Ribble Valley Borough Council
Housing & Development Control

Application no: **3/2022/1158**

Address: **Land South of Accrington Road Whalley**

Proposal: **Erection of 17 dwellings and 57 apartments with associated access, roads, car parking, landscaping and infrastructure, including a public car park to serve Whalley town centre**

Drawing file: planx_downloads / 22_1158_Highway_Setting_Out_Plan.pdf

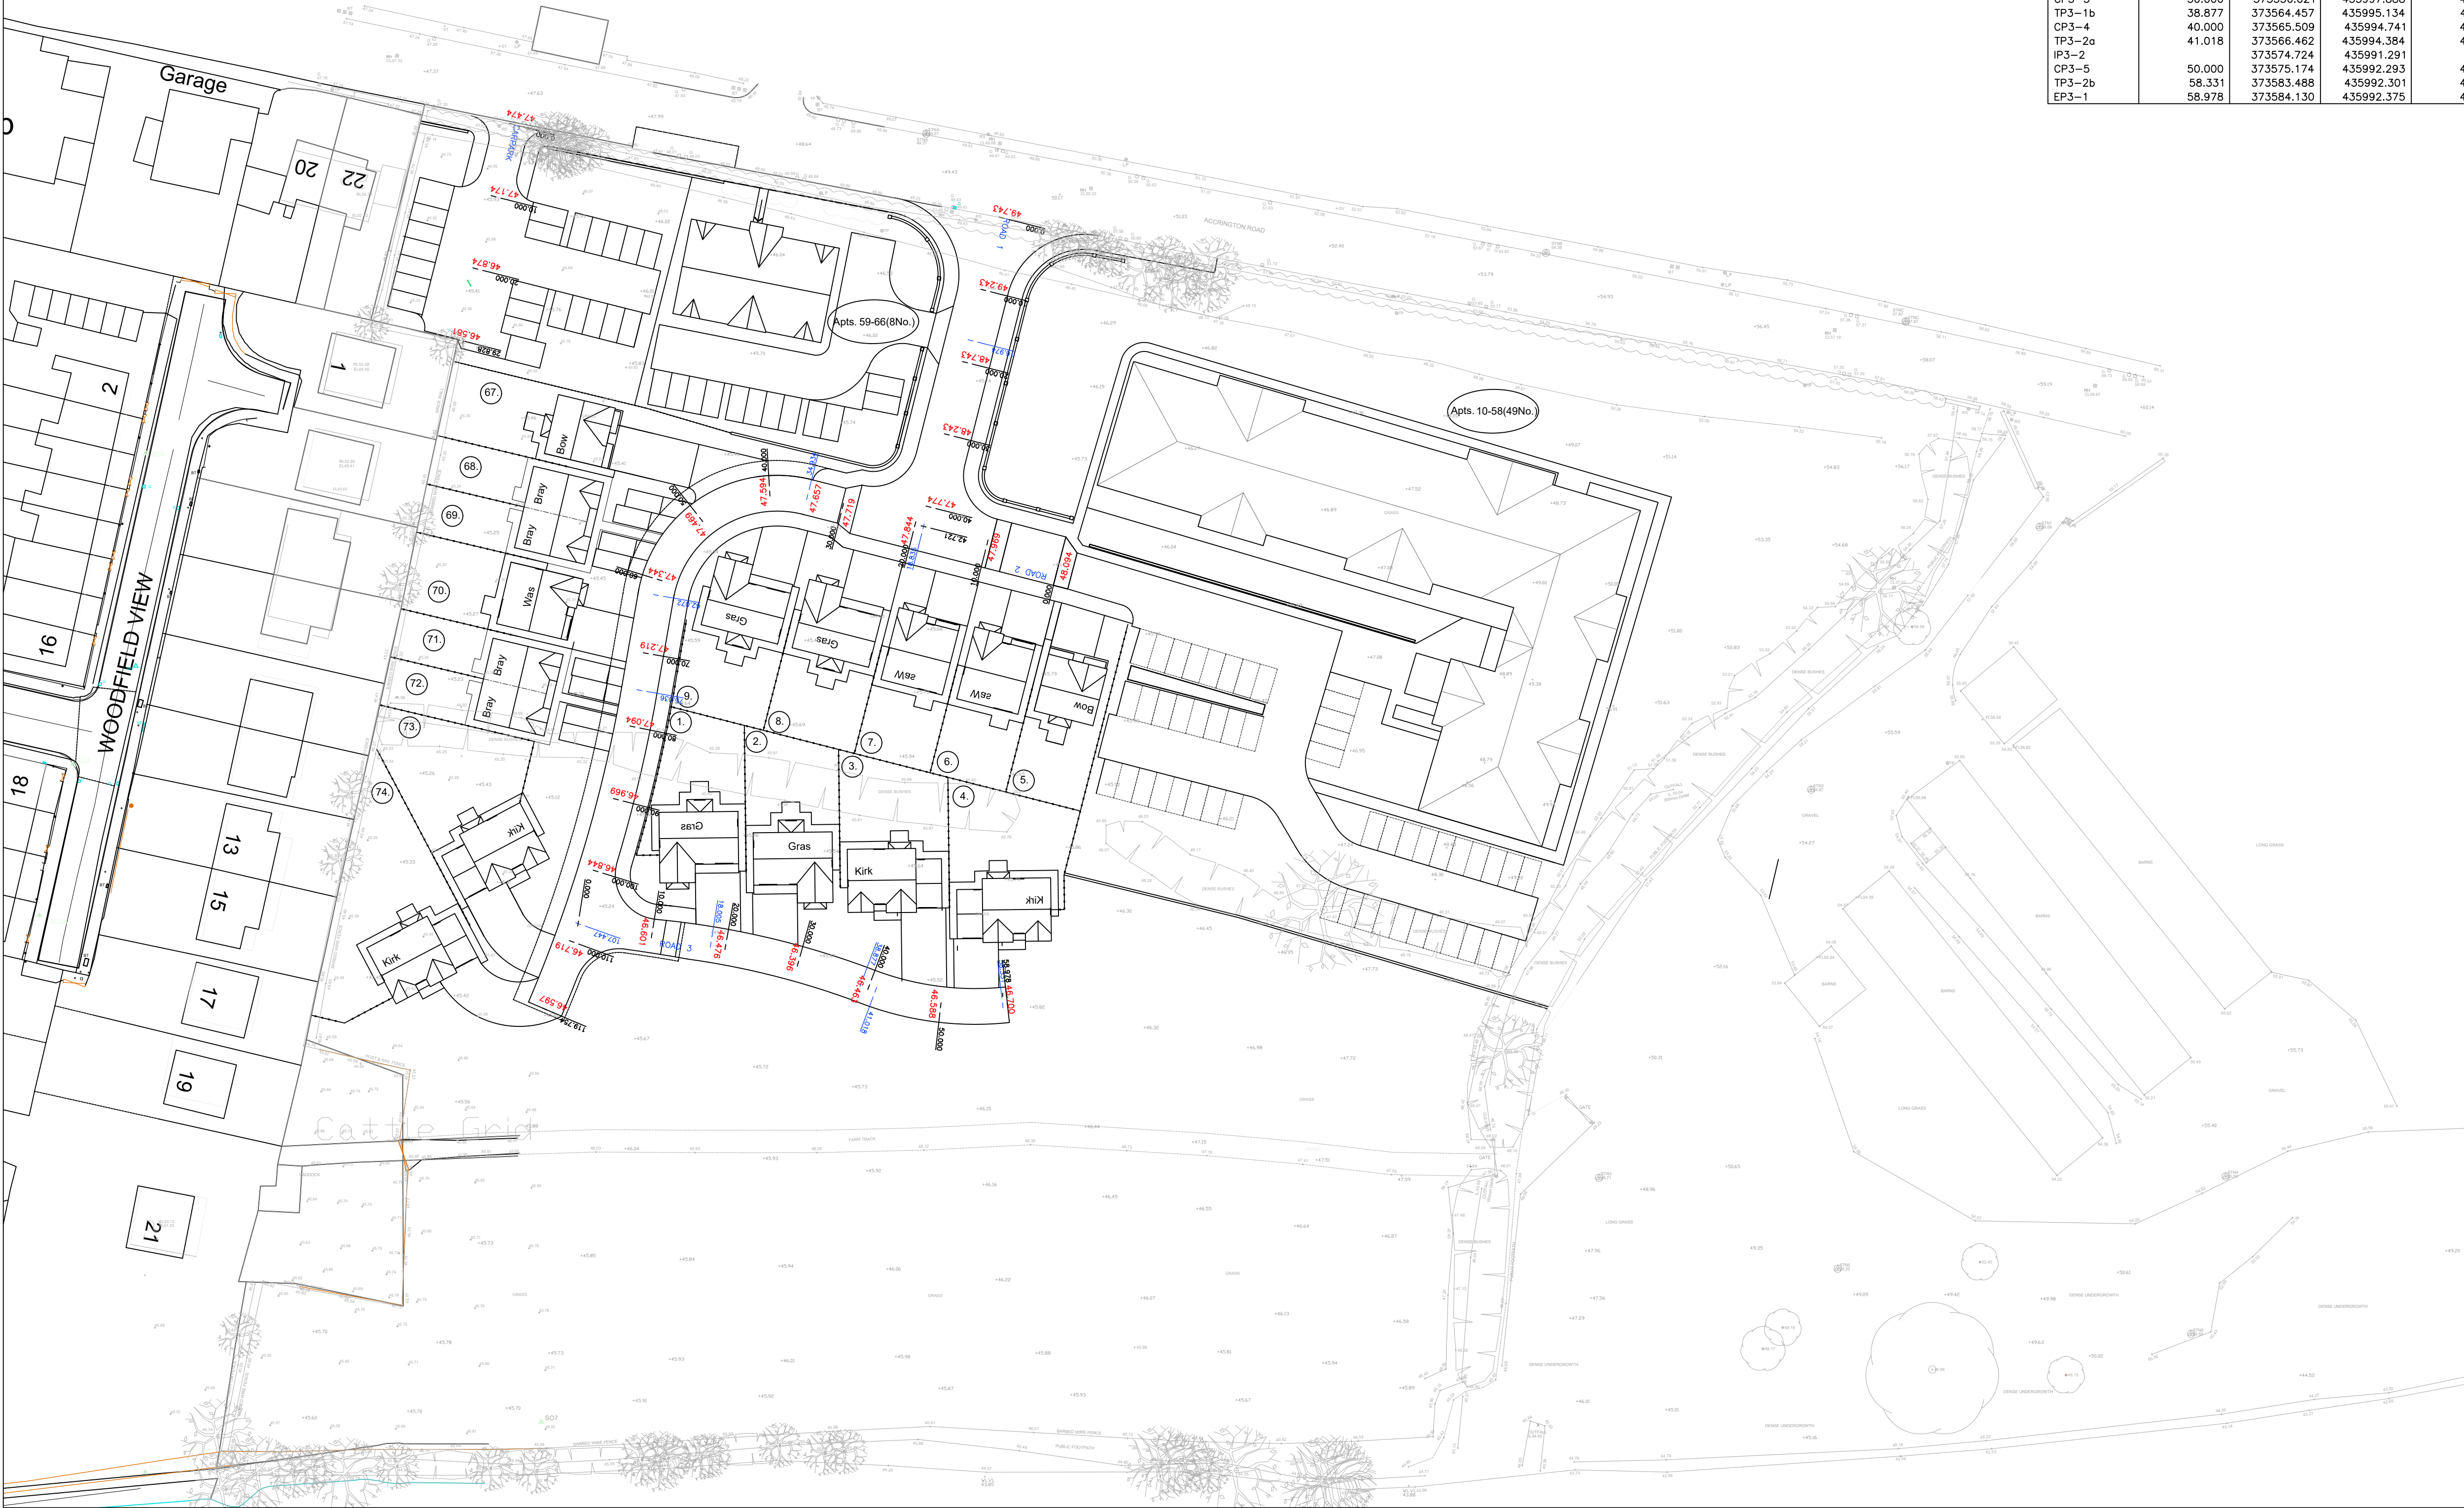
The LHA remind the Agent that the embankment which will be located adjacent to the proposed footway to the right of the access, should not exceed a gradient of 1 in 3. Unfortunately, in places by reviewing M & P Gadsden drawing number 21315- GAD- 00- ZZ- DR- C-1501 Rev P02 titled " Phase 1 Highway Setting Out", the gradient exceeds this level and so further amendments should be made to the plans.
